**JOHN & HILDE GERATHY
34/10 LINCOLN CR WOOLLOOMOOLOO 2011
OWNERS**

Development Application / EIS— SSD 6471 Submission re SYDNEY MODERN (SM)

drawing	East & West Elevations																																									
drawing no.	DA_3001																																									
Revision	C

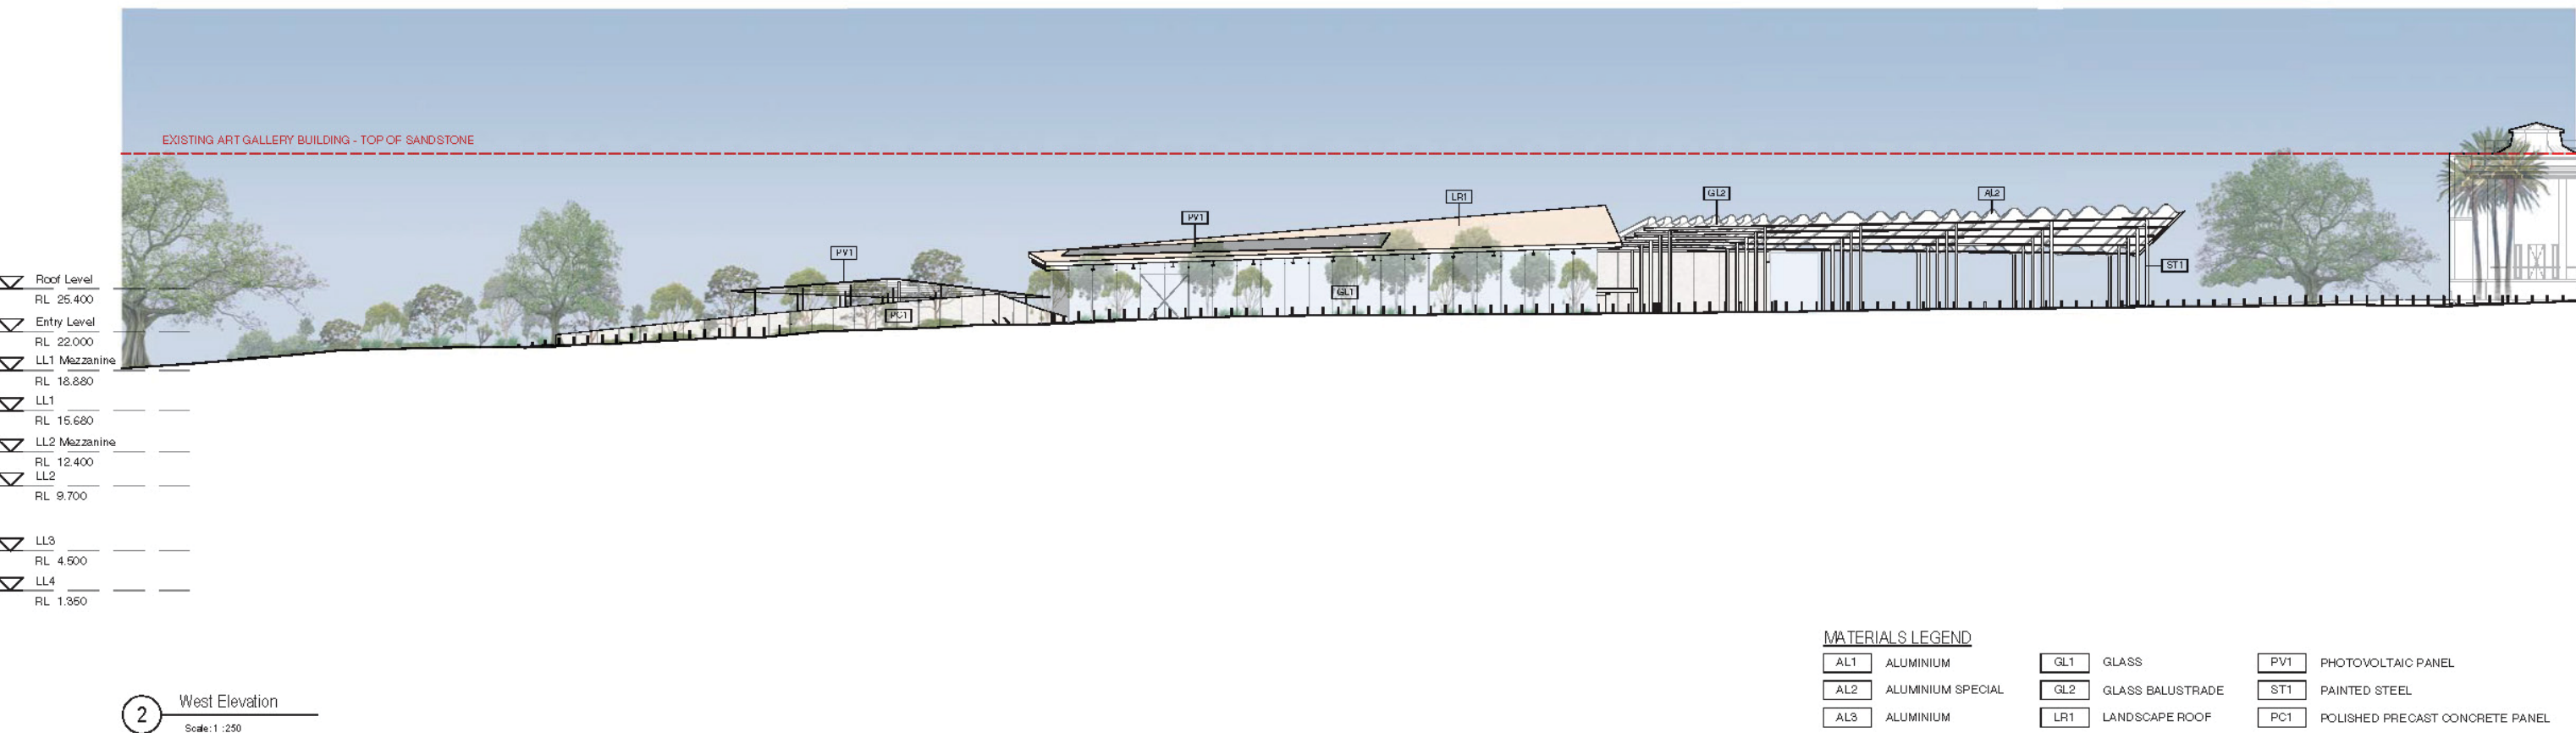
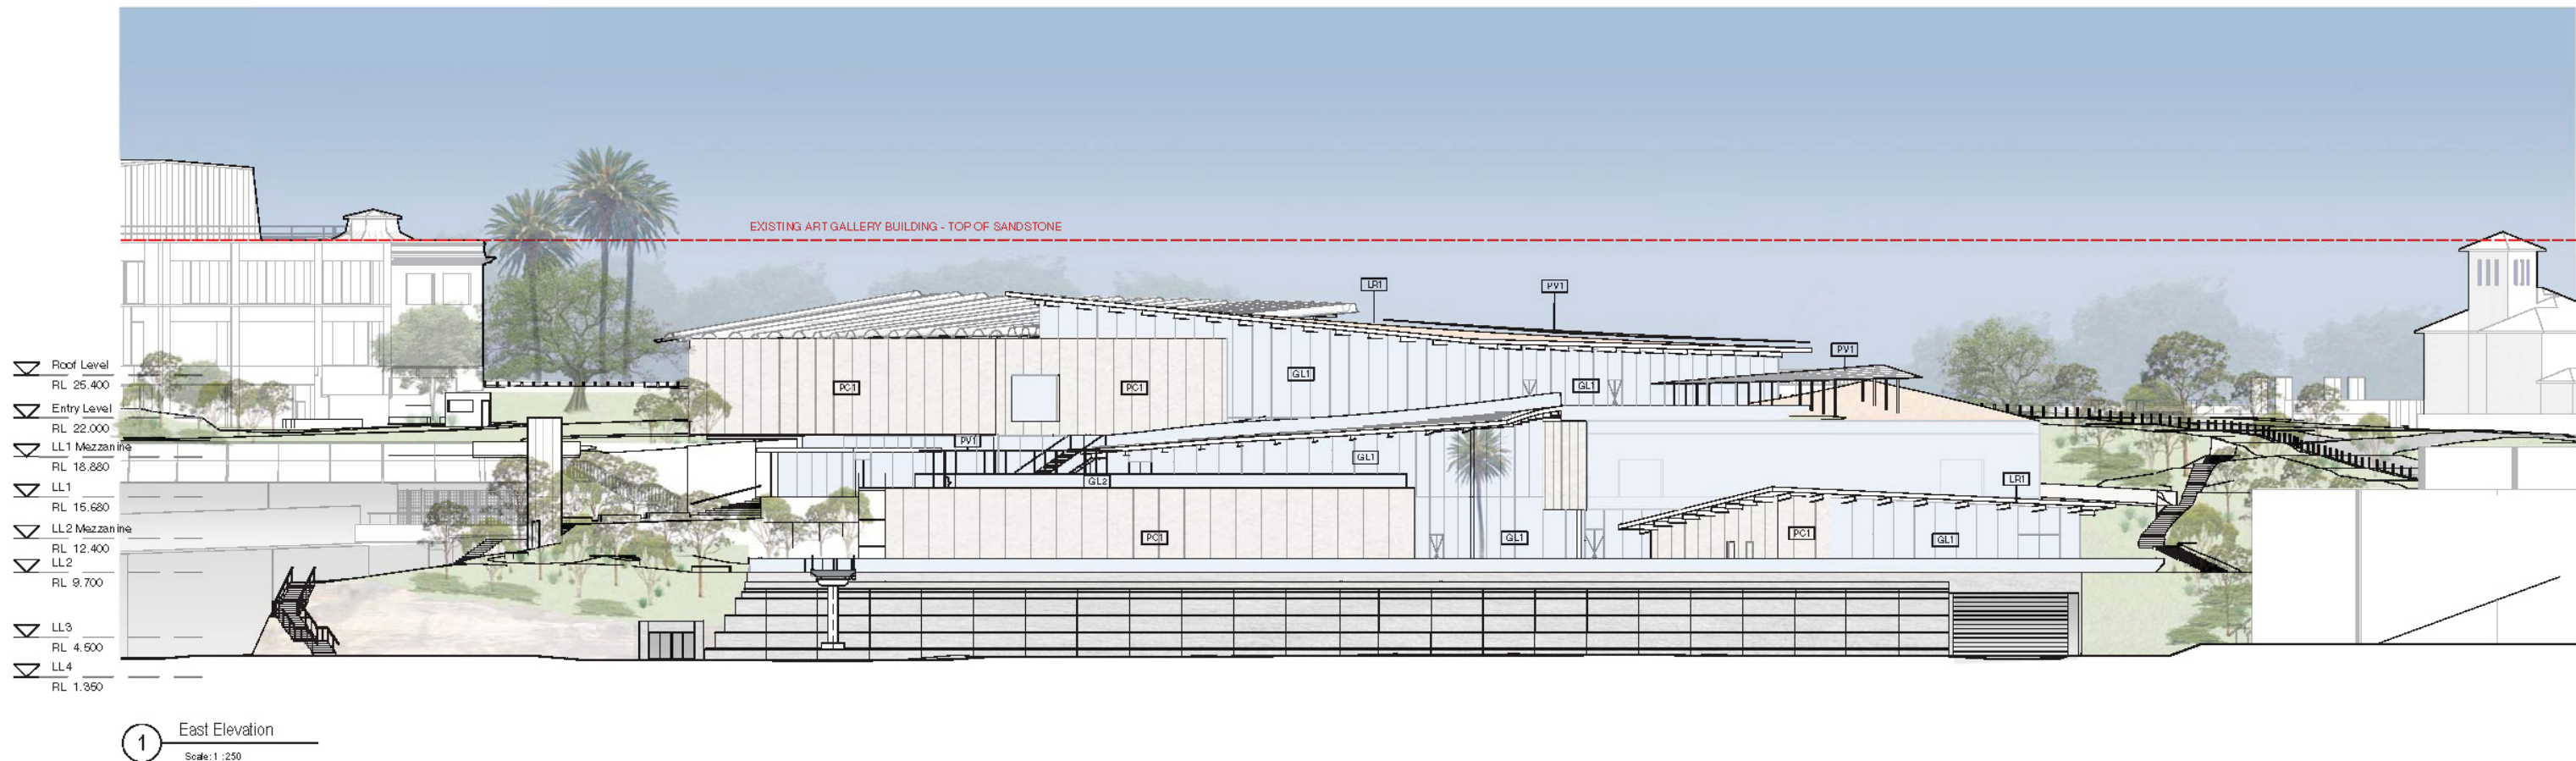
The siting of the lower Pavilion immediately above TWT on top of the existing industrial stepped naval concrete bunker wall will present a 14 metre (5 storey- refer attached Section Plan) solid concrete/ masonry 42-metre-long WALL right on Lincoln Cres without landscaping or architectural relief. There is a pavilion roof structure above the wall extending the height by another storey. This wall will create an overbearing canyon effect on entering Lincoln Cres when combined with the relatively robust western façade of TWT (albeit TWT is only two stories high).

The eastern wall of the Lower Pavilion, sited virtually on the top of the stepped wall, has NO RELIEF whatsoever.

It is suggested that this wall have vertical fenestrations (sheeted over internally if necessary for Gallery purposes) or similar trompe-l’oeil /architectural relief. It is, after all, a Modern Art Gallery!

Alternatively, or in addition the Pavilion could be set back 1.5 metres and a row of mature palms planted along it’s façade.

The plans do not show any fencing along the path between the Pavilion and top of the stepped wall. Details should be produced before submissions close.
